Comments on the Applicant's Response to Deadline 3 Submissions [Part 9 - Noise] by William David Moore

Introduction

00:00 on 26/04/2021 to 00:00 on 27/04/2021

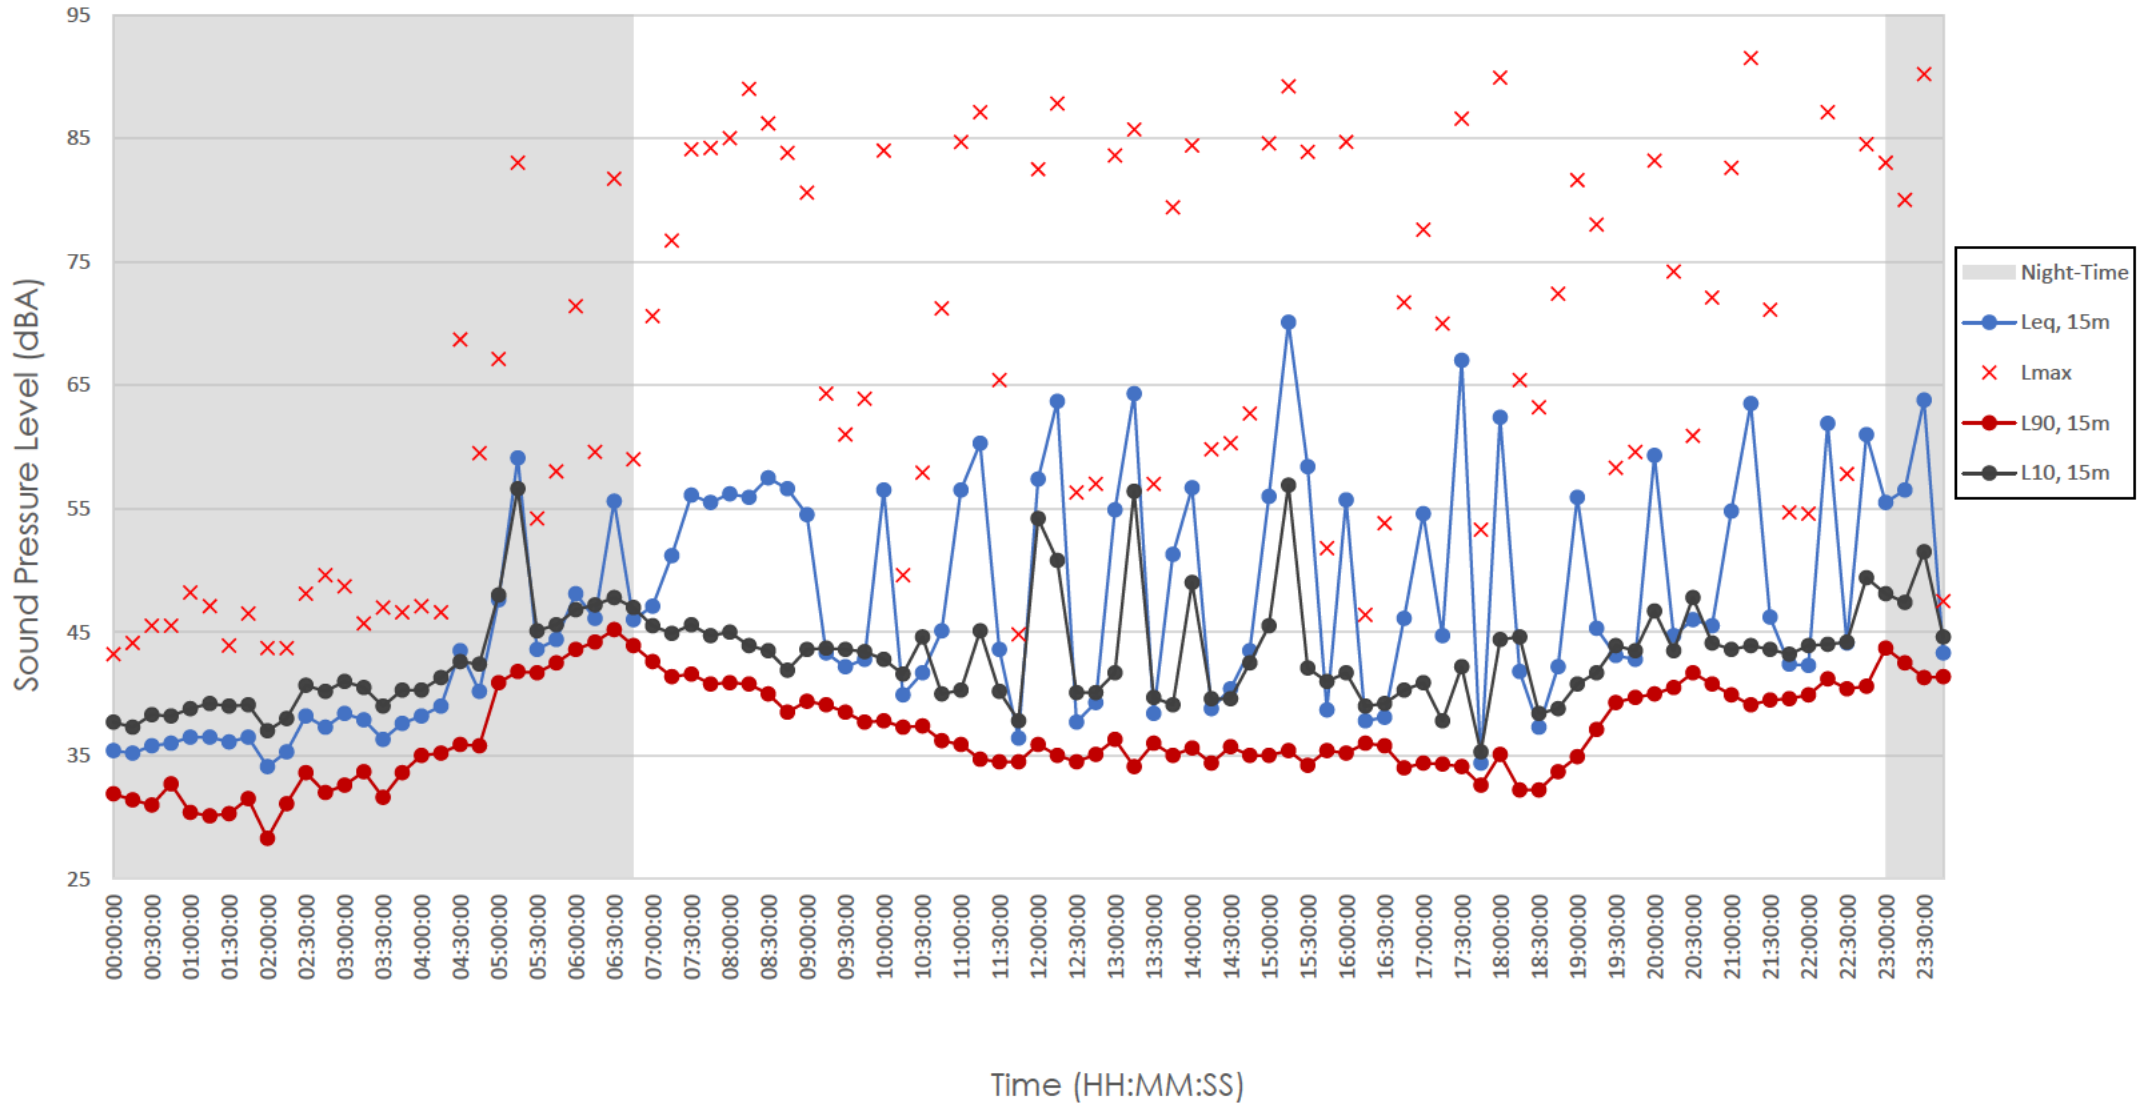
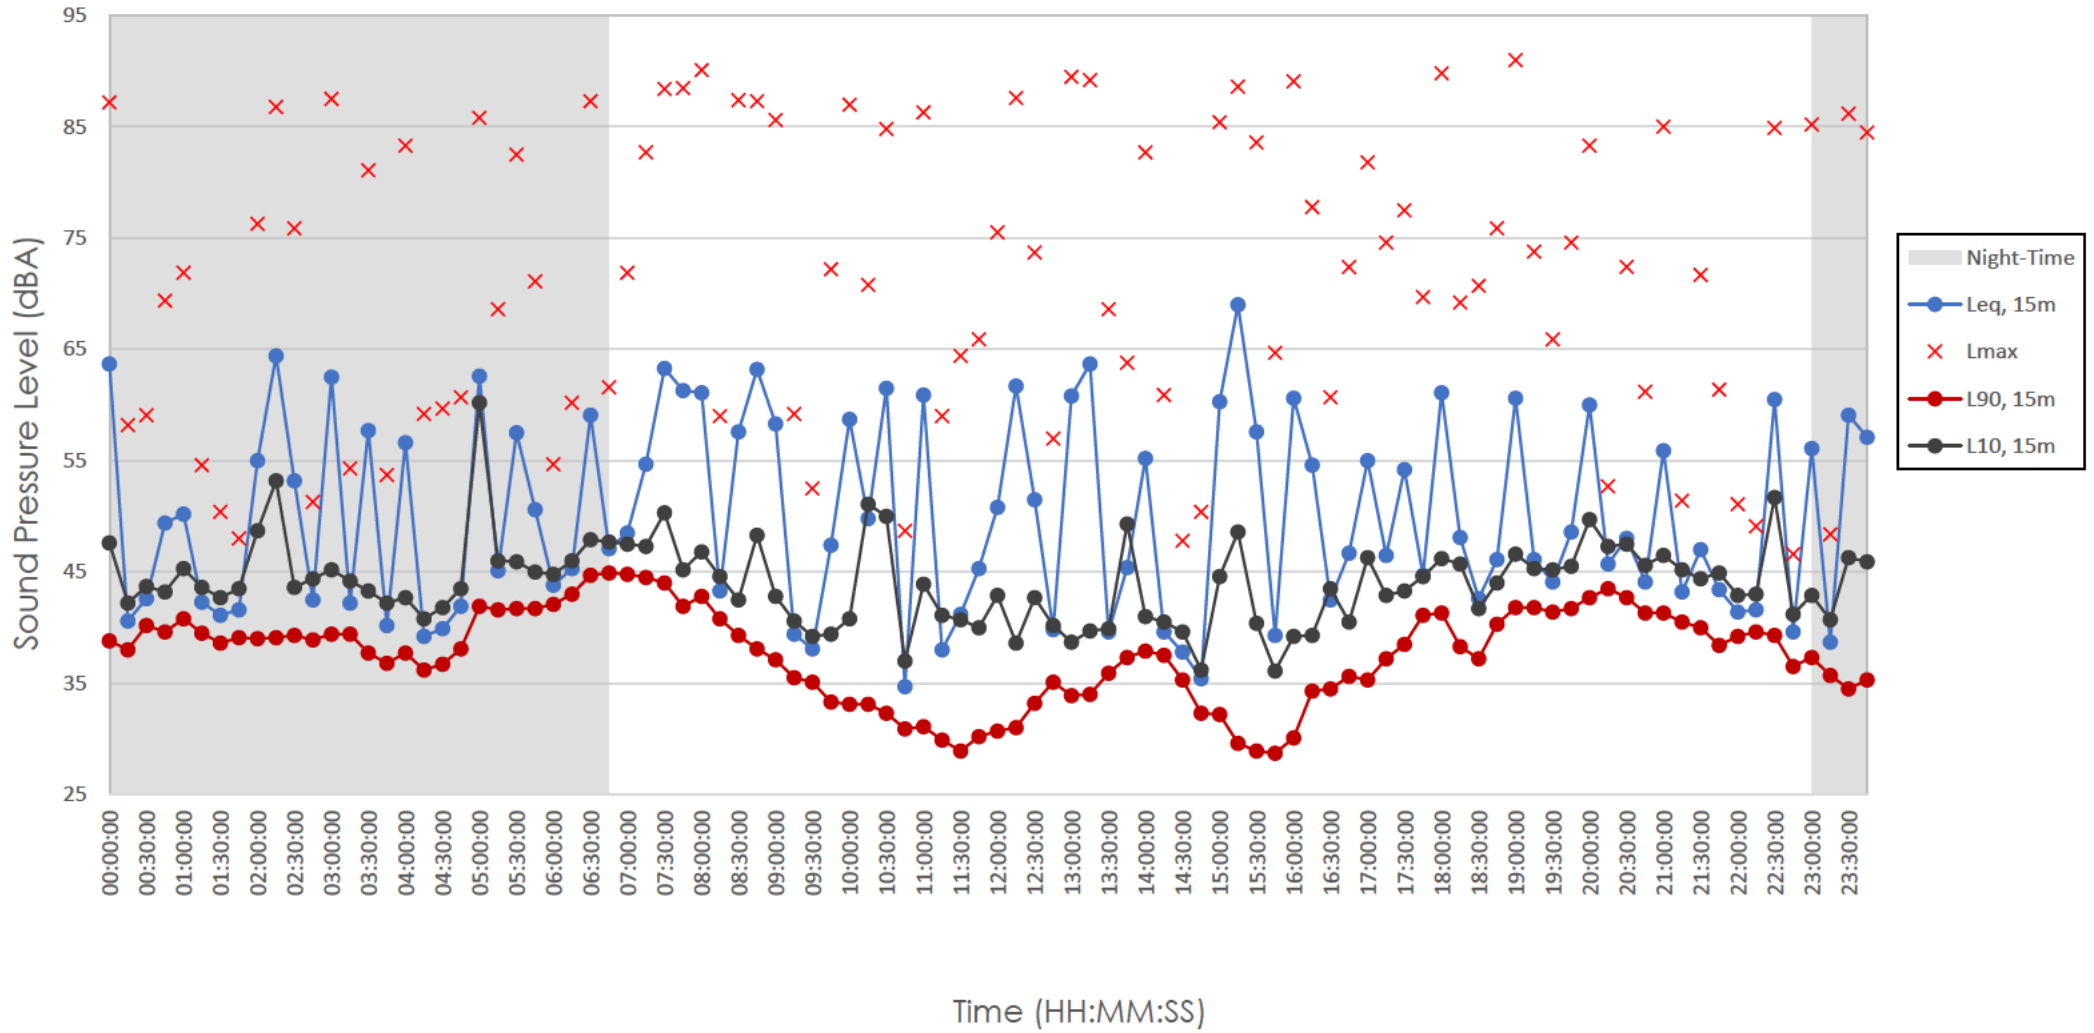
The applicant is retreating to strategic contours. We have levels measured on the ground at the site: The measurements of NMP3 & NMP4. Both of those NMPs show sound levels far lower than those depicted by the strategic contours which the applicant is attempting to rely on.

This section set the scene at Burbage Common & Woods, highlighting that the monitoring at NMP3 - in extremely close proximity to the railway line - contains the sound of extremely close proximity train pass bys which unsurprisingly caused large spikes in measured LAeq values during those periods when trains passed by.
